# Rezoning Transportation Analysis

Petition Number: 2020-017

| Date       | Description       |
|------------|-------------------|
| 06-24-2020 | Third Review (KP) |

**REZONING PLAN
RZ-1**

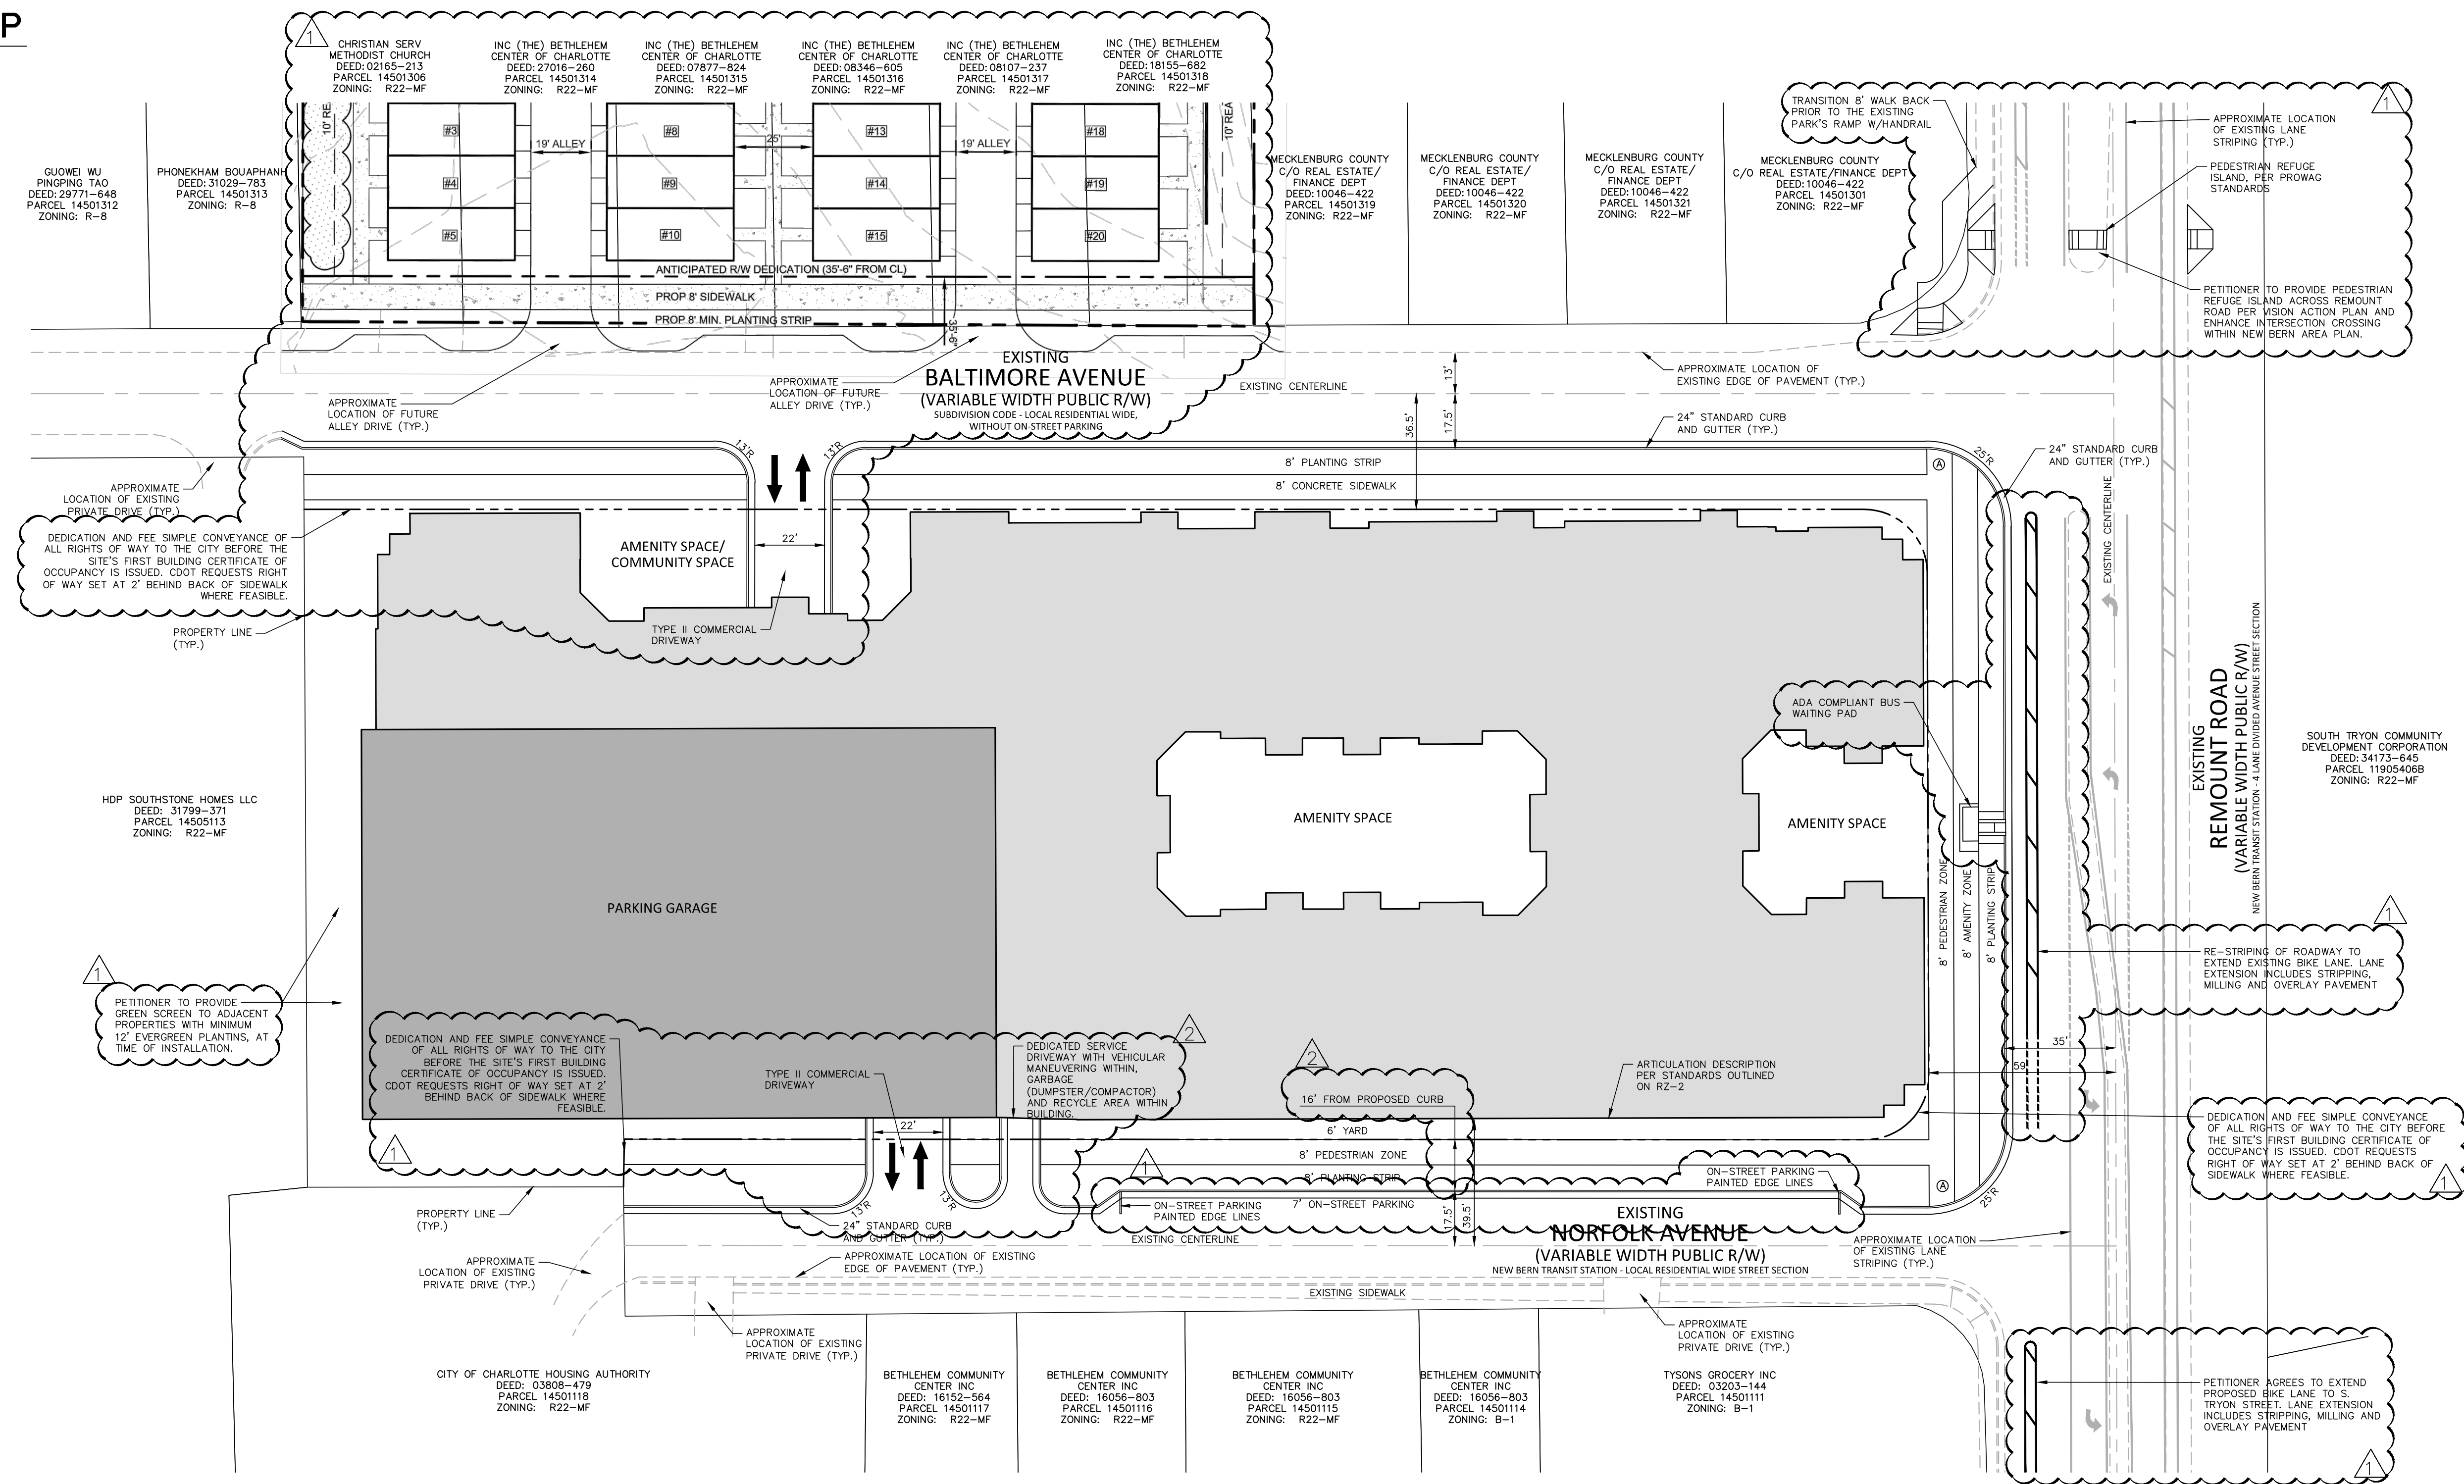
4. ~~Resolved~~ We request the petitioner to revise the site plan and conditional note(s) to construct a pedestrian refuge island across Remount Road, in reference to the Vision Zero Action Plan and enhanced intersection crossing included within the New Bern Area Plan. CDOT has notified Mecklenburg County of the possibility of the petitioner possibly attaining public utility and construction easements to improve the streetscape at this intersection. Please contact Jacqueline McNeil at ([Jacqueline.McNeil@mecklenburgcountync.gov](mailto:Jacqueline.McNeil@mecklenburgcountync.gov)) or (980-314-2511) and Bert Lynn at ([Bert.Lynn@mecklenburgcountync.gov](mailto:Bert.Lynn@mecklenburgcountync.gov)) or (704-589-7491). The pedestrian refuge may be unsignalized, but should still include MUTCD pedestrian crossing signage with a marked crosswalk. Please provide CDOT with an exhibit to review.

5. ~~Resolved~~ The petitioner is required to revise the site plan and conditional note(s) to widen the proposed access on Baltimore Avenue to a CLDSM standard for two-way traffic.

- 14. **Resolved** In reference to the Charlotte BIKES adopted plan and CDOT Streets Map, CDOT requests the petitioner to revise the site plan and conditional note(s) to restripe the area below to replace the existing eastbound right turn lane in favor of extending the buffered bike lane to the intersection of Tryon Street. This request is also supported to establish a constant bike facility connection to the Rail Trail directly into South End.

RZ-1

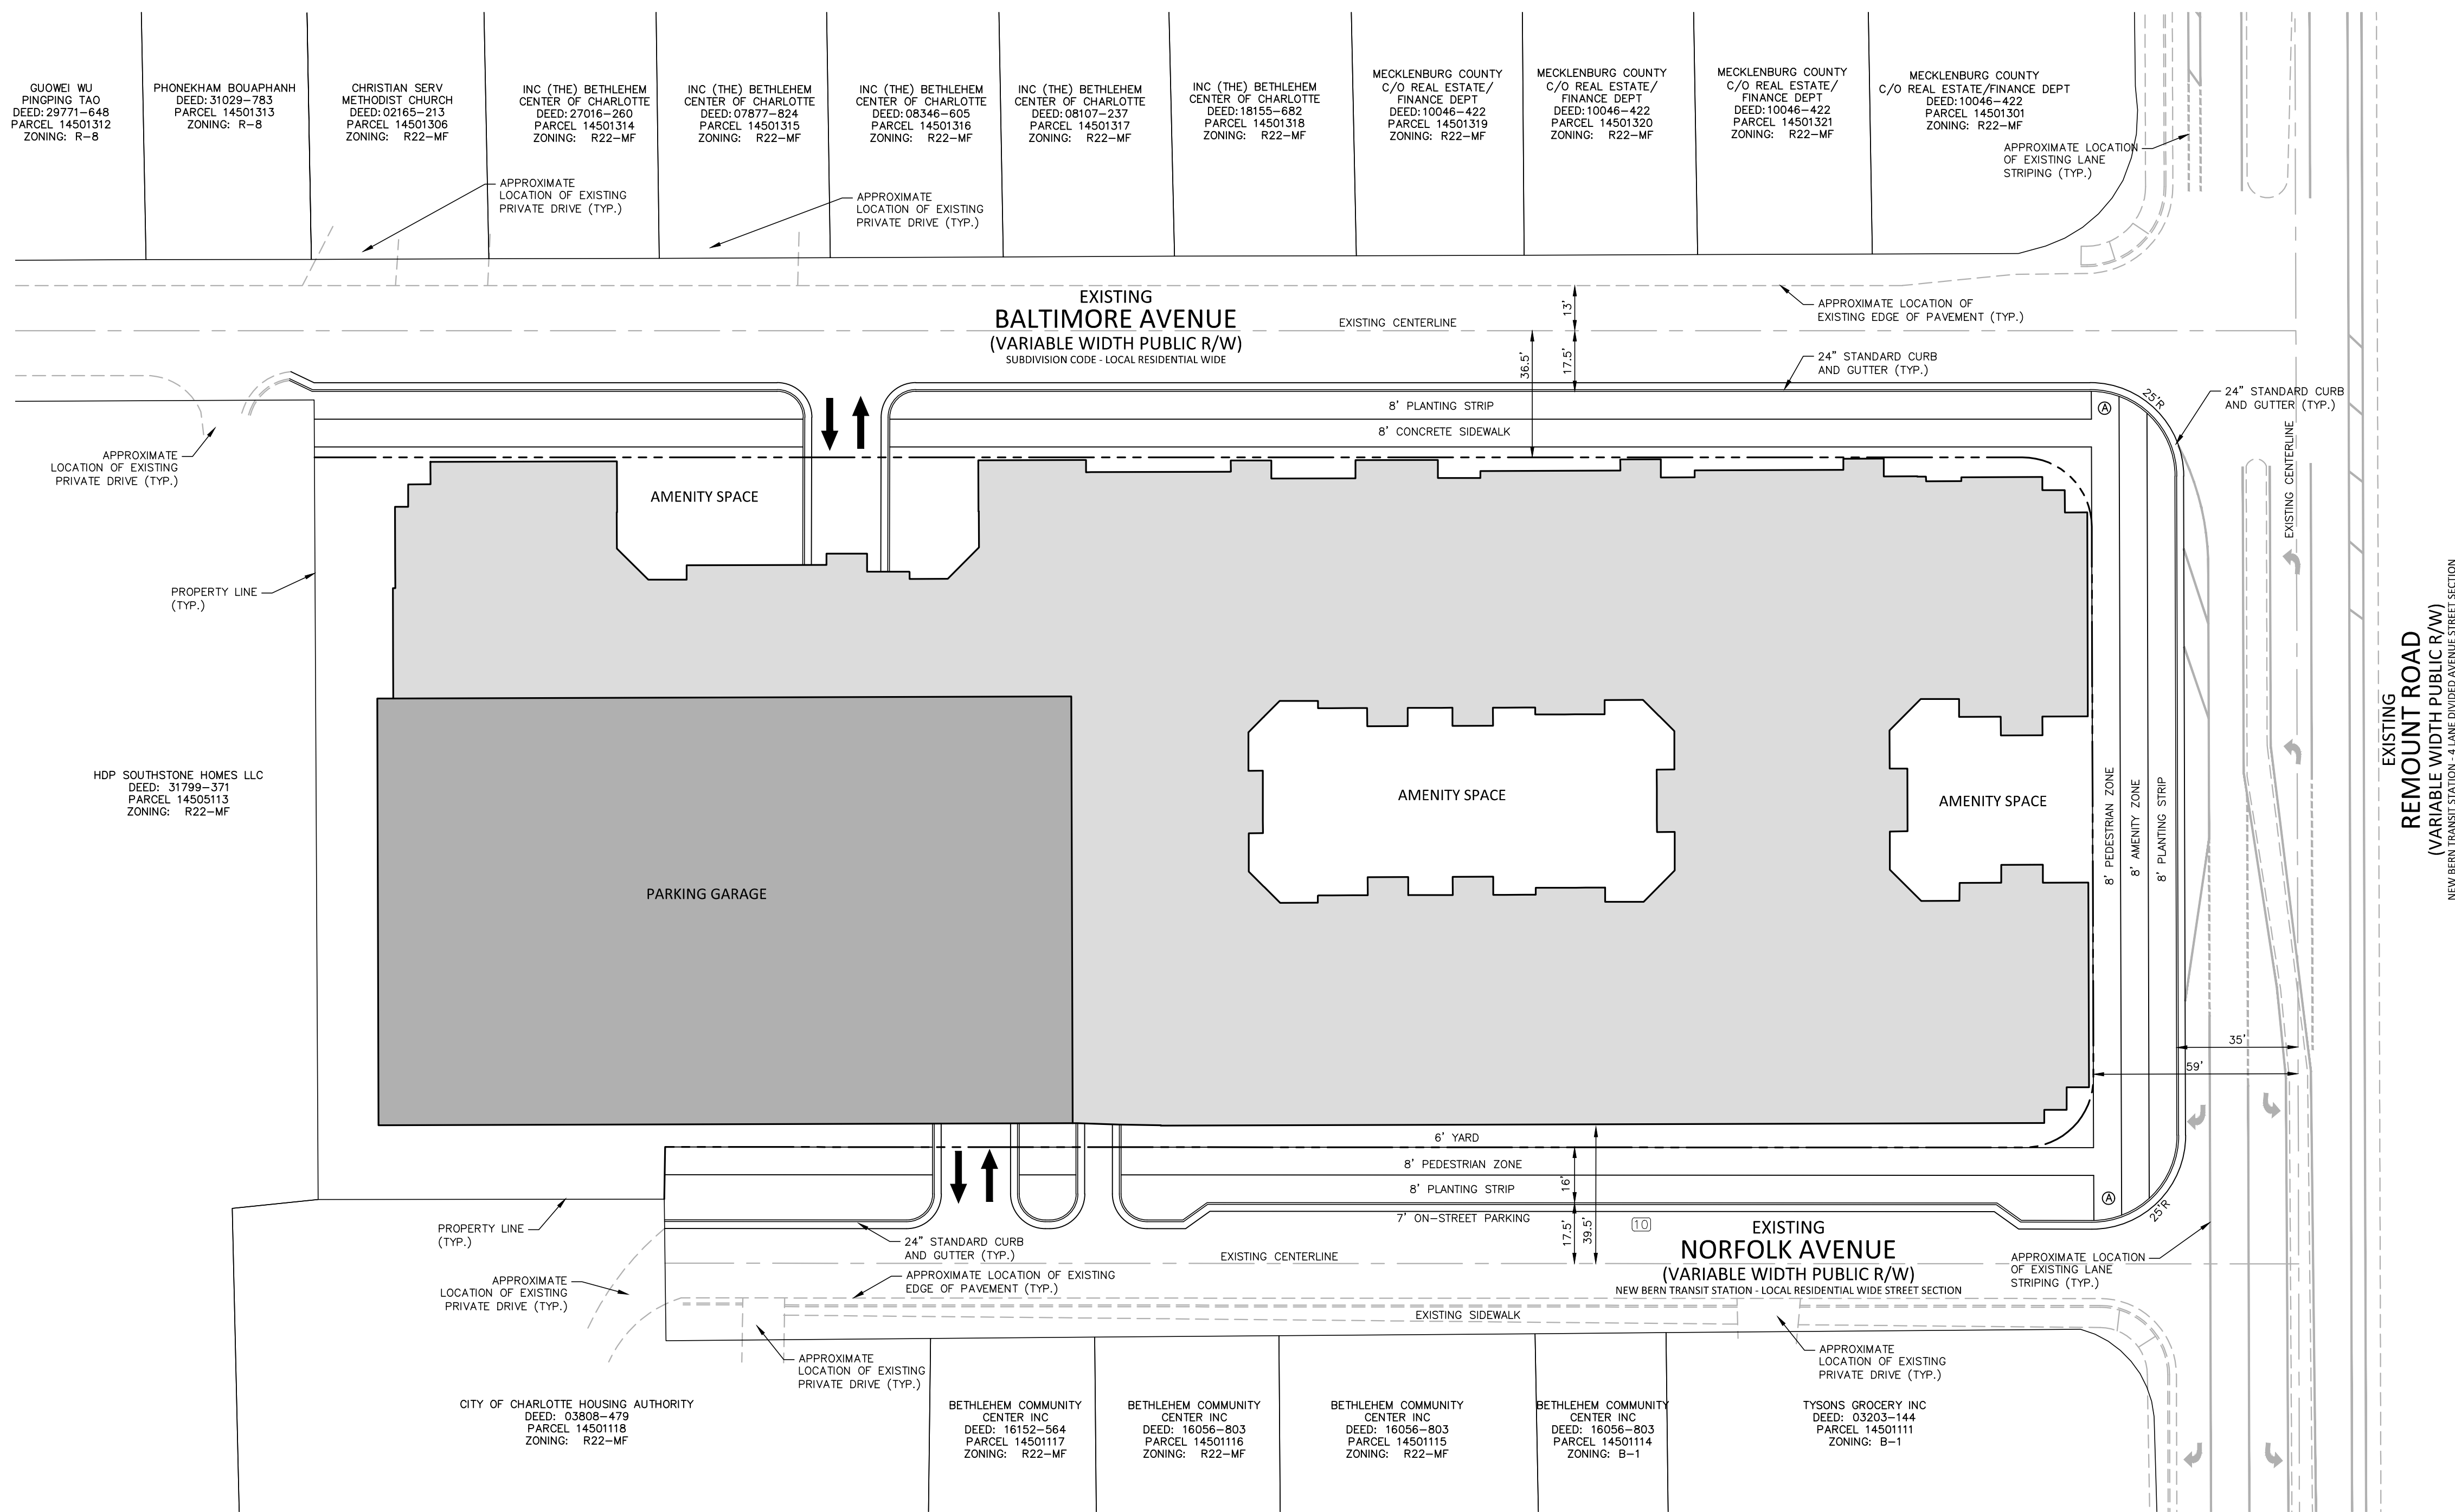
8. **Resolved** The petitioner should revise the site plan and conditional note (Section IV. Transportation, 3) to add specify dedication and fee simple conveyance of ~~all~~ rights of way to the City before the site's first building certificate of occupancy is issued. CDOT requests right of way set at 2' behind back of sidewalk where feasible.
9. **Resolved** The petitioner should revise the site plan and conditional note(s) to remove the proposed access on Norfolk Avenue, as shown below.

10. **Resolved** The petitioner should revise the site plan and conditional note(s) to clarify if the Norfolk Avenue on-street parking will be used to count toward Zoning Ordinance parking requirements. If so, one accessible on-street parking space will be required, affecting the proposed streetscape along Norfolk Avenue.

- a. **Technical Clarification** The petitioner should revise the site plan to show the edge line measured parallel to the edge of pavement and curb line.

12. **Outstanding** The petitioner should revise the site plan and conditional note(s) to clarify the trash container locations and how handling will be performed.
13. **Rescinded, bicycle parking is required per Section 12.202 and 12.202A of the Zoning Ordinance.**  
~~The petitioner should revise the site plan and conditional note(s) to include the location of Zoning Ordinance required bicycle parking.~~
14. **Resolved**~~Sample format for comment that is resolved~~
